Addendum No. 1

RE: Contract # C204078

Orange County (B-4962)

BRIDGE #46 OVER ENO RIVER ON US-70 BYPASS

REVISIONS						SHEET NO.
NO.	BY:	DATE:	NO.	BY:	DATE:	S-5
1	D.A.G.	3/27/19	3			TOTAL SHEETS
2			4			47

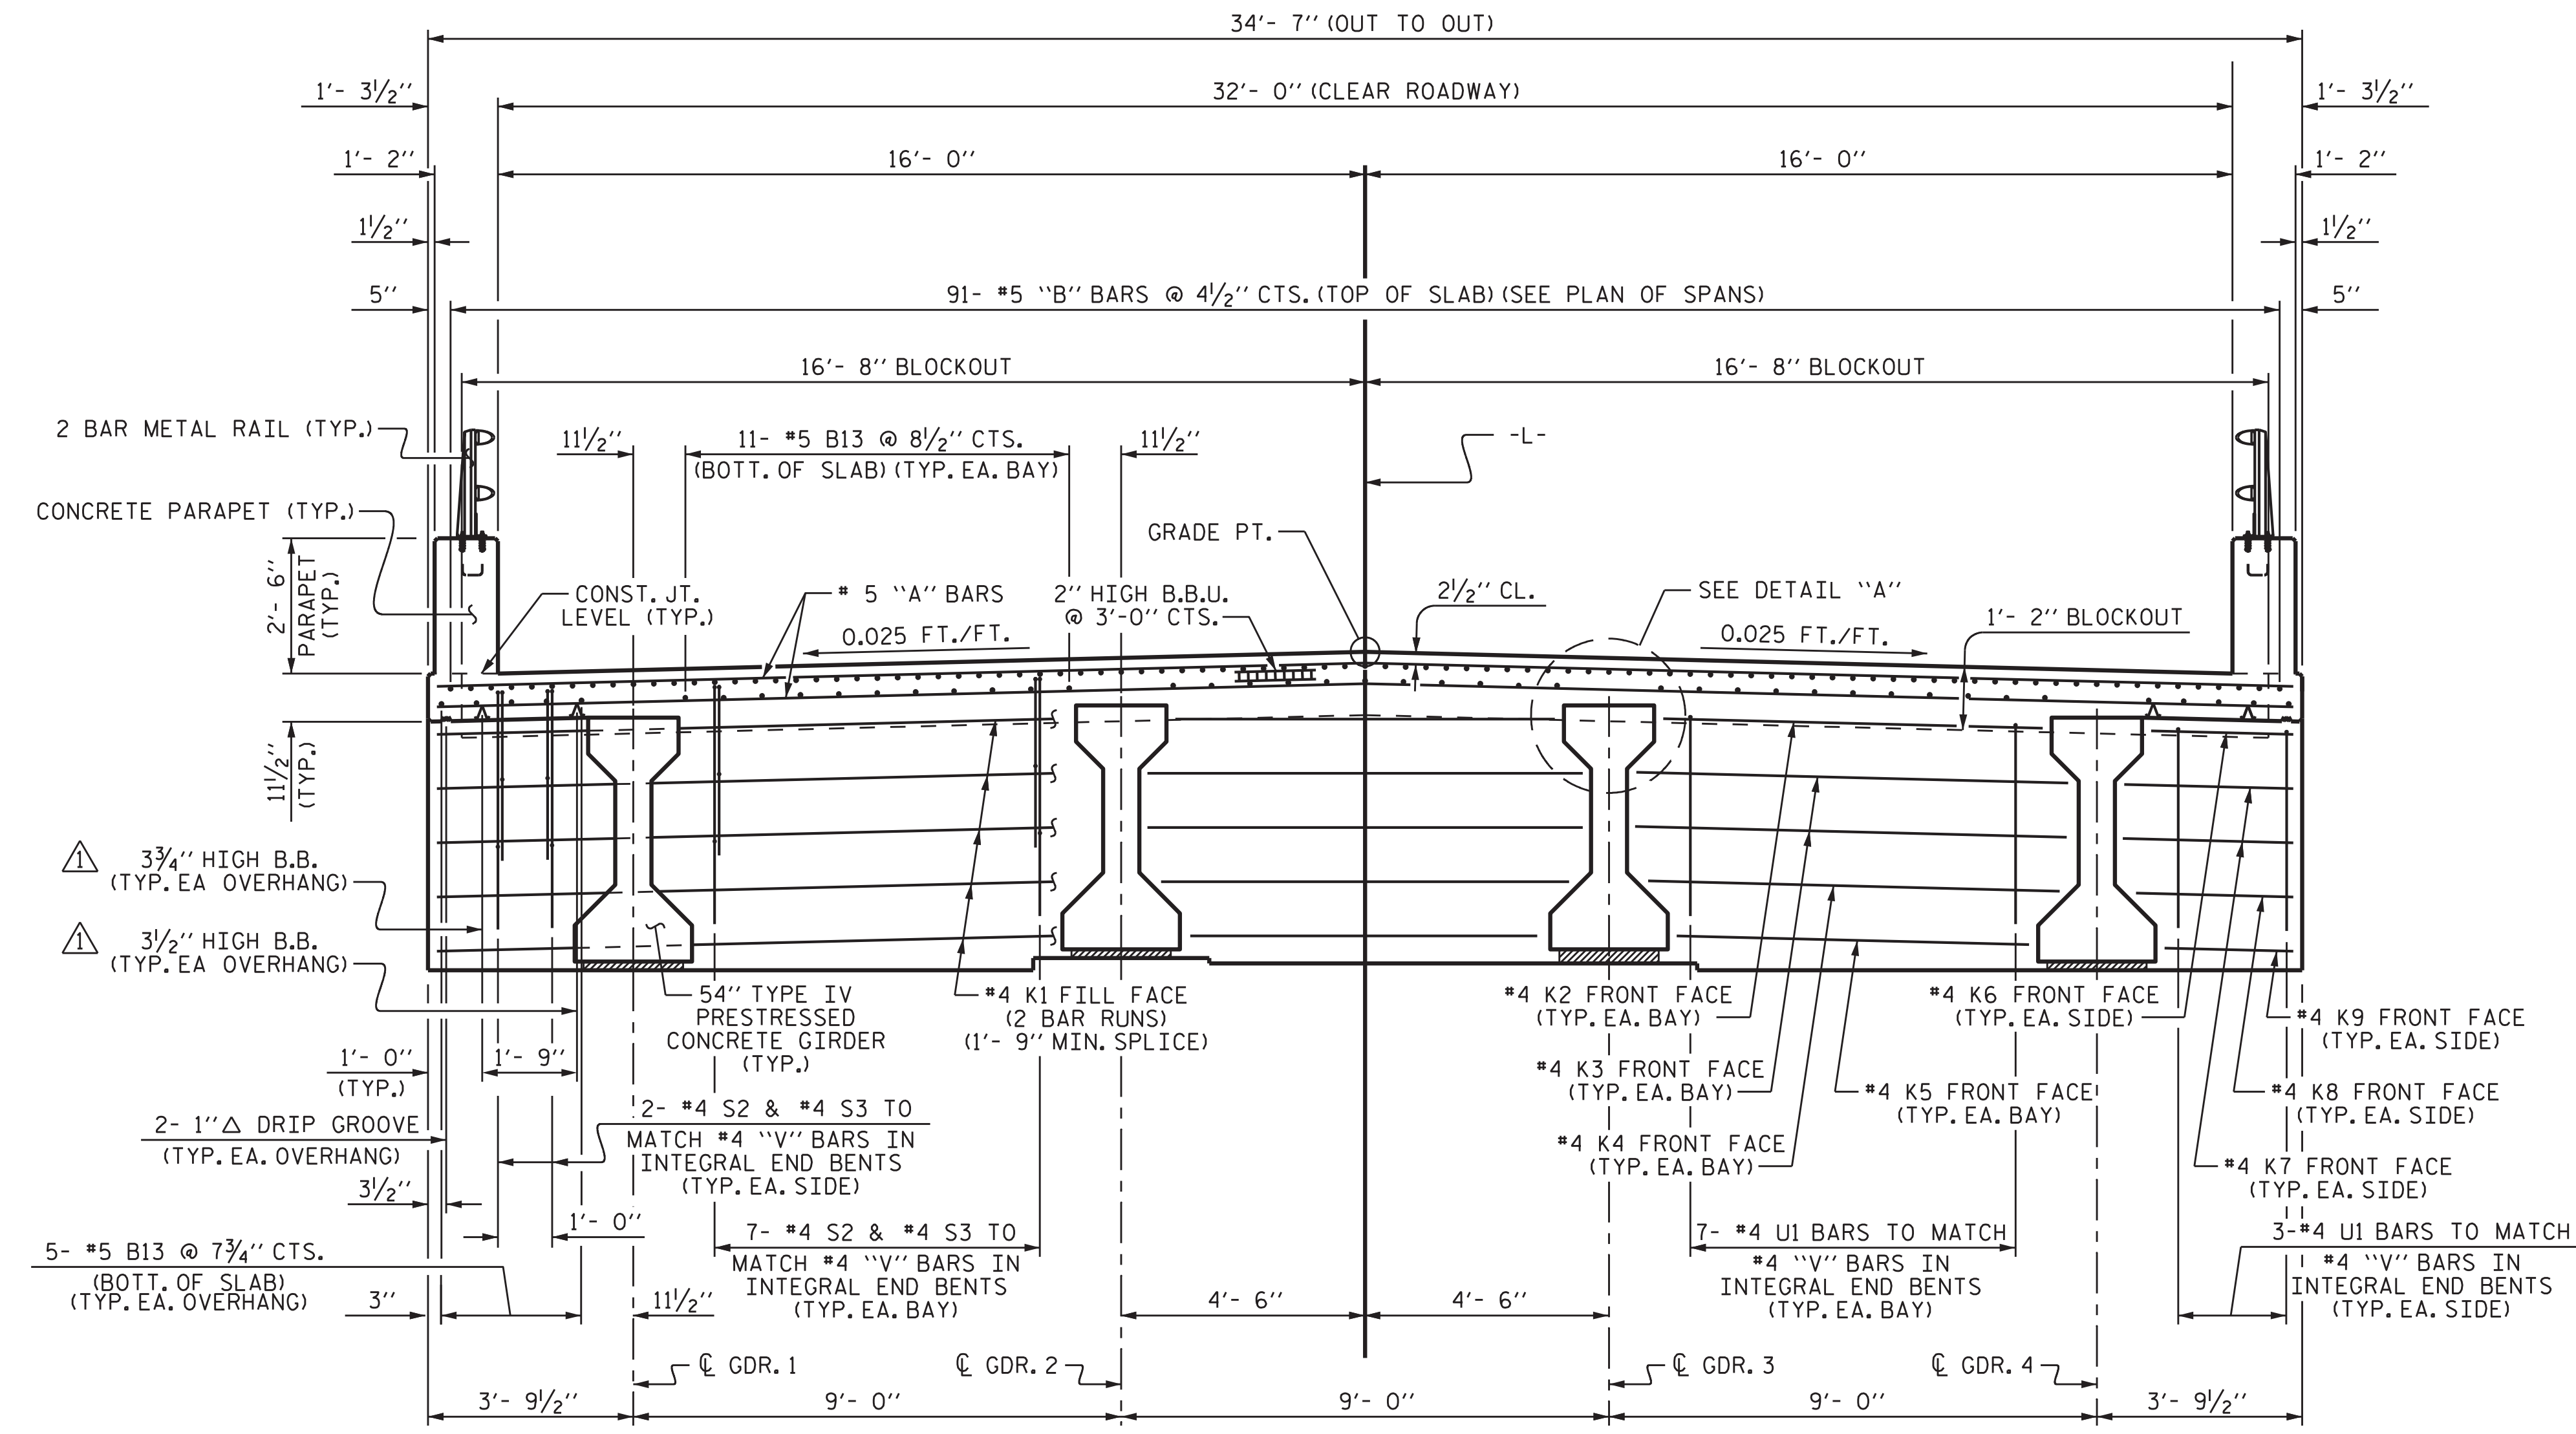
Sheet No.	Revisions
S-5 thru S-7	Revised to correct beam bolster dimensions.

⚠️ ADDED BEAM BOLSTER HEIGHT IN BOTTOM OF OVERHANGS.

REVISIONS						SHEET NO.
NO.	BY:	DATE:	NO.	BY:	DATE:	S-6
1	D.A.G.	3/27/19	3			TOTAL SHEETS
2			4			47

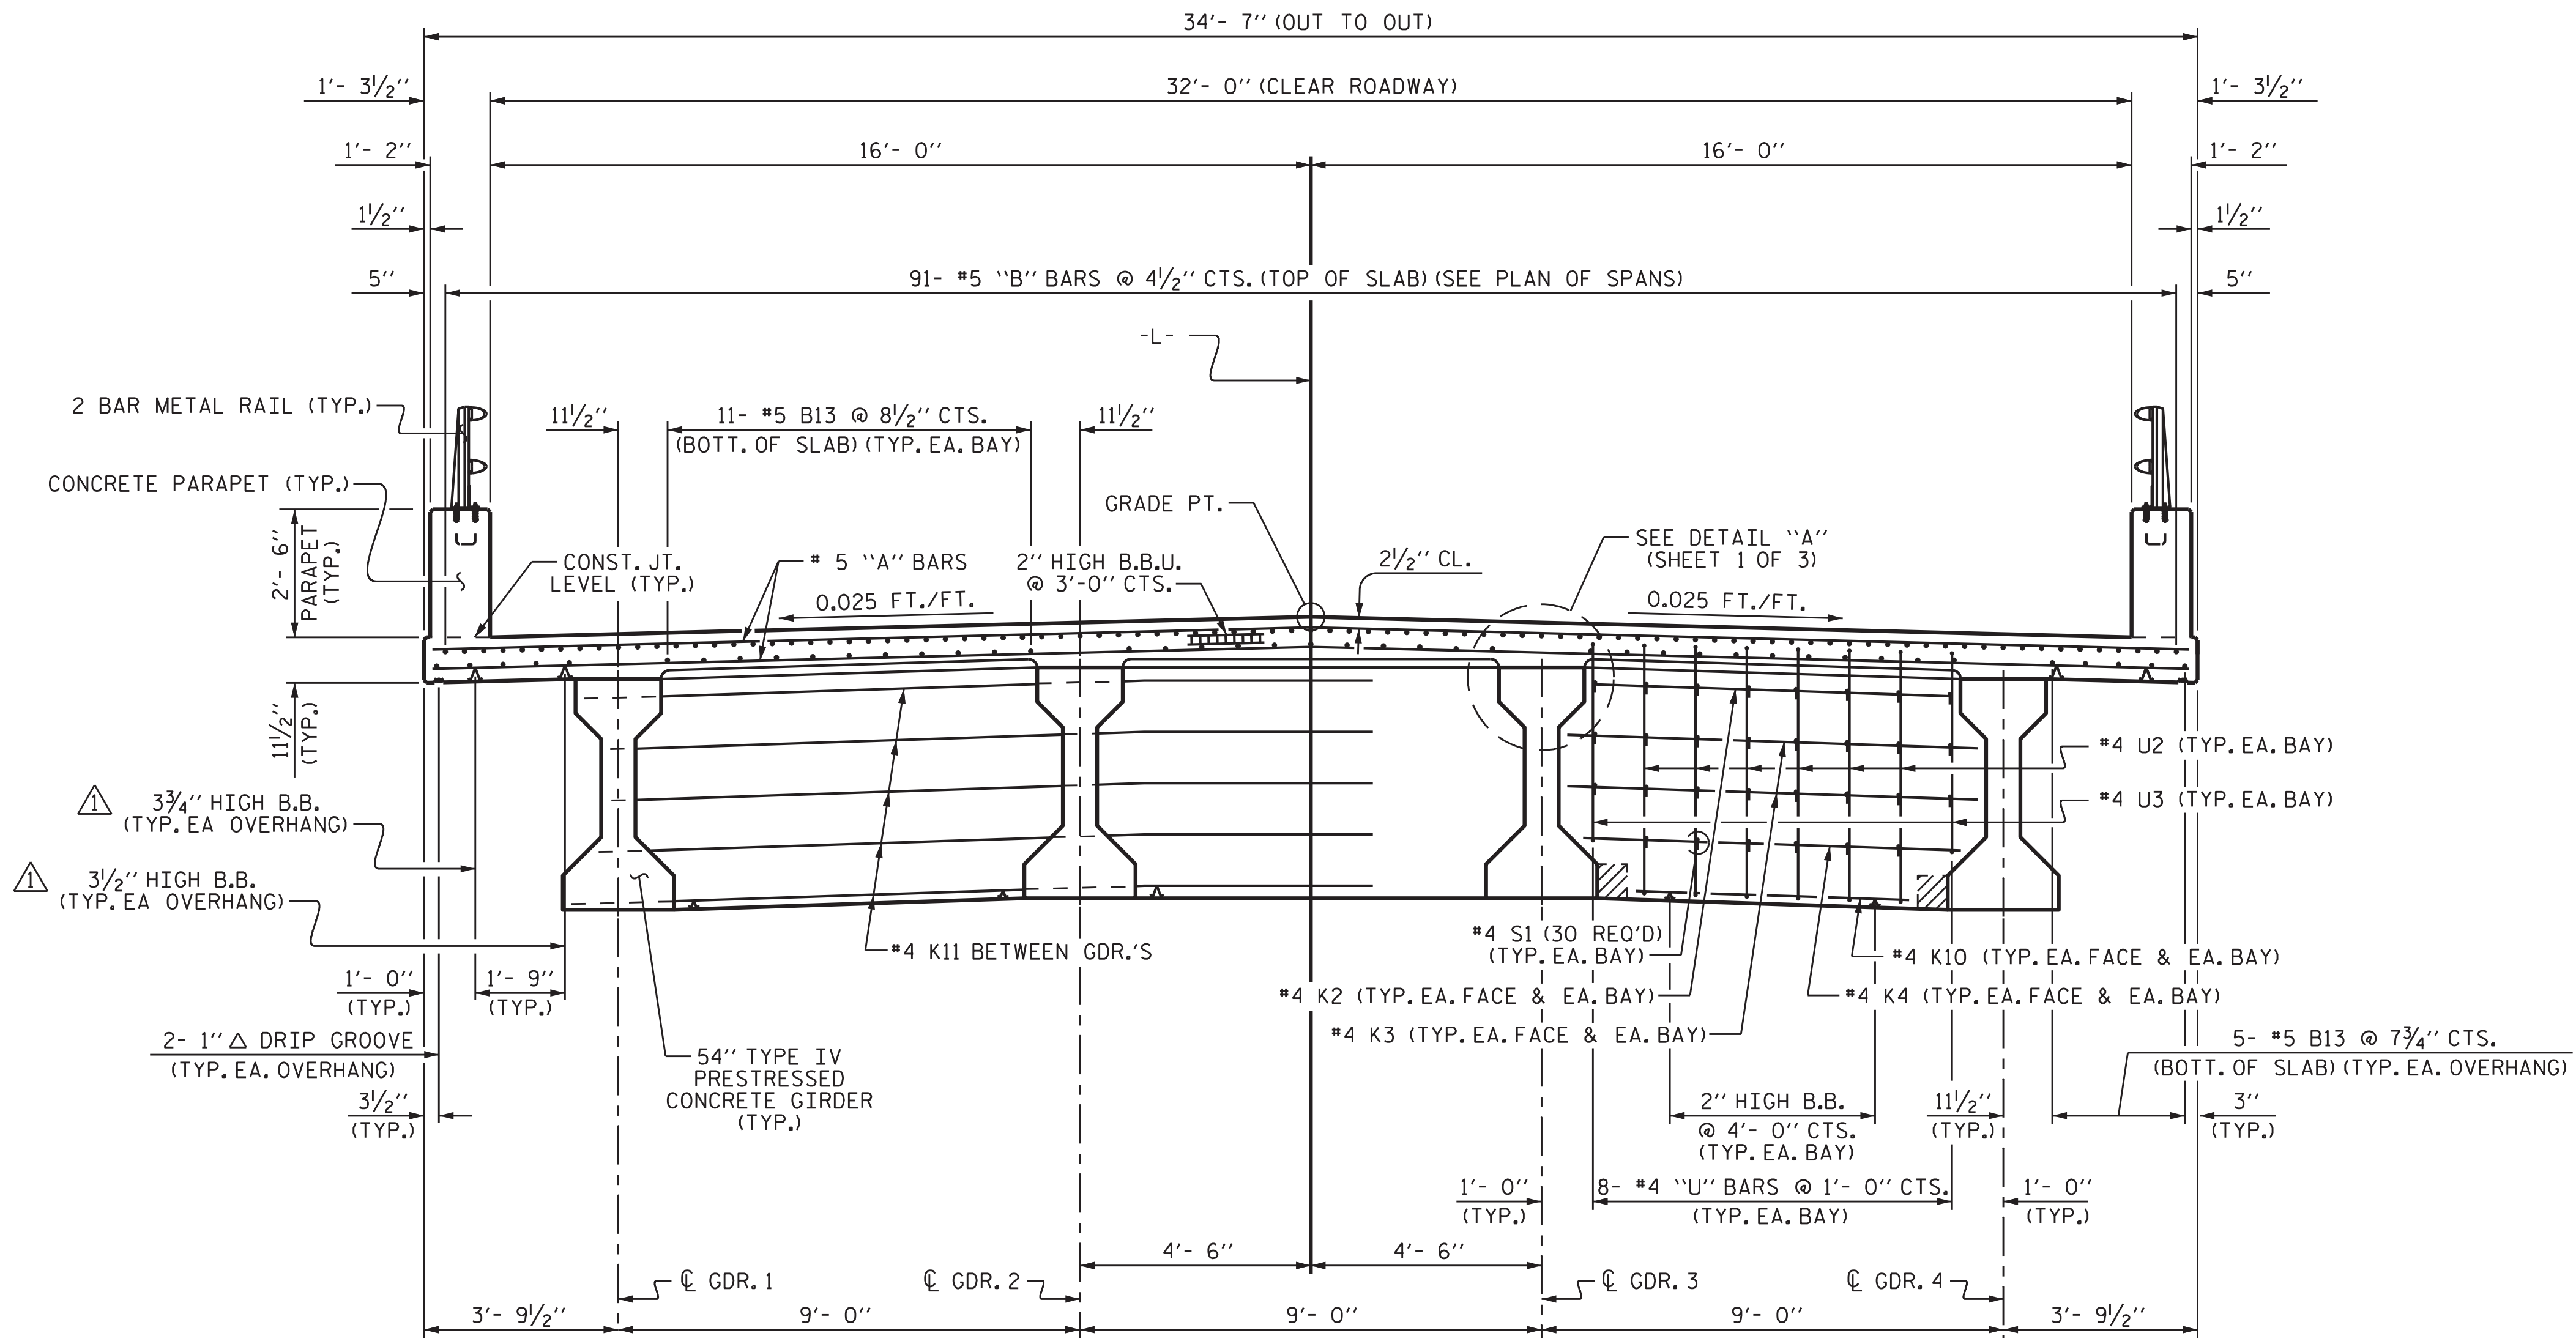
⚠️ ADDED BEAM BOLSTER HEIGHT IN BOTTOM OF OVERHANGS.
